**FOR AN ORDER GRANTING DEVELOPMENT CONSENT
FOR THE SEA LINK PROJECT**

(REF: EN020026)

**DEADLINE 5: PORT OF LONDON
AUTHORITY'S COMMENTS ON SUBMISSIONS
RECEIVED AT DEADLINE 4**

Plate 1.1 Cable route overview showing stakeholder areas of concern in relation to water depth

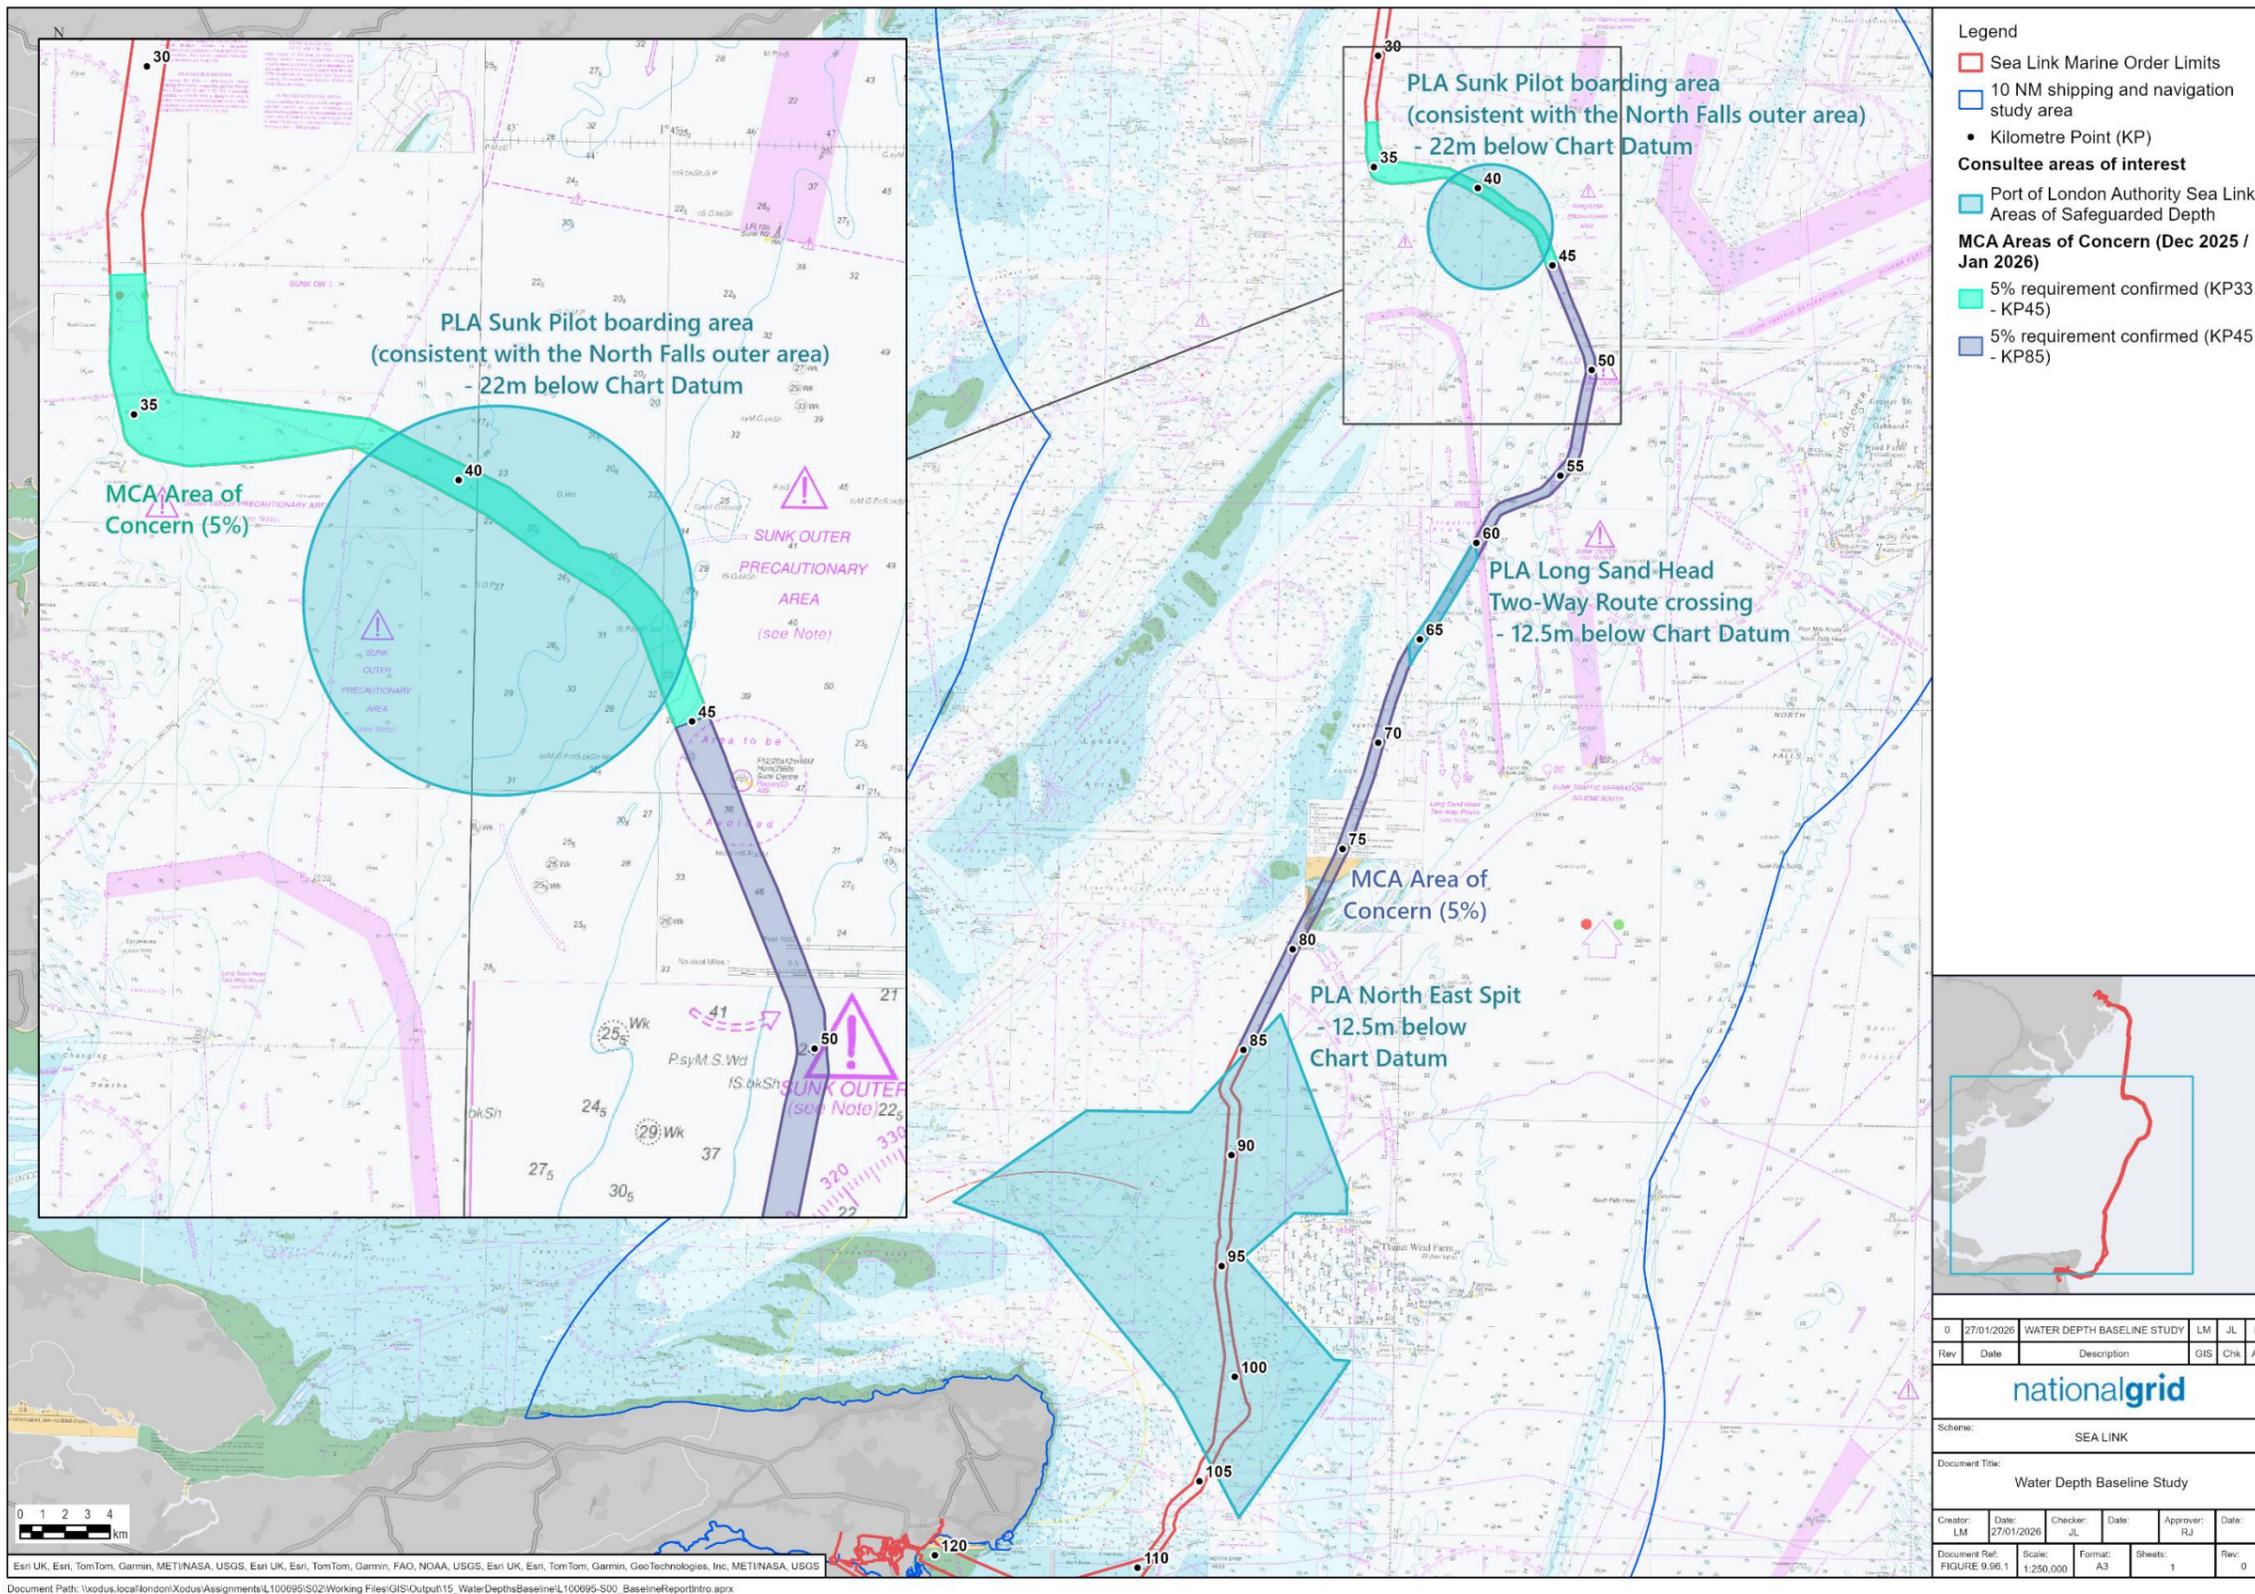
- 11.2 The PLA would suggest that the maximum 5% limit on water depth reduction as proposed by the MCA, is extended to include the NE Spit Area of Safeguarded Depth to approximately KP105. This would be consistent with the approach taken at the other two areas of absolute safeguarded depth to ensure areas currently deeper than the safeguarded depths are also not subject to significant reductions.

- 11.3 The data presented in the various plates show that vessels in excess of 12.5m draught do navigate in the NE Spit area to access the Tongue Deep Water Anchorage or to board/land pilots in adverse weather to access the ports by other routes. In addition to the risk of cable burial not being achieved, there are a number of cable crossings (Britned, Nautilus, Mercator etc) which will inevitably reduce water depths and adherence to the 5% maximum reduction would be appropriate in addition to the absolute 12.5m requirement to mitigate these impacts.
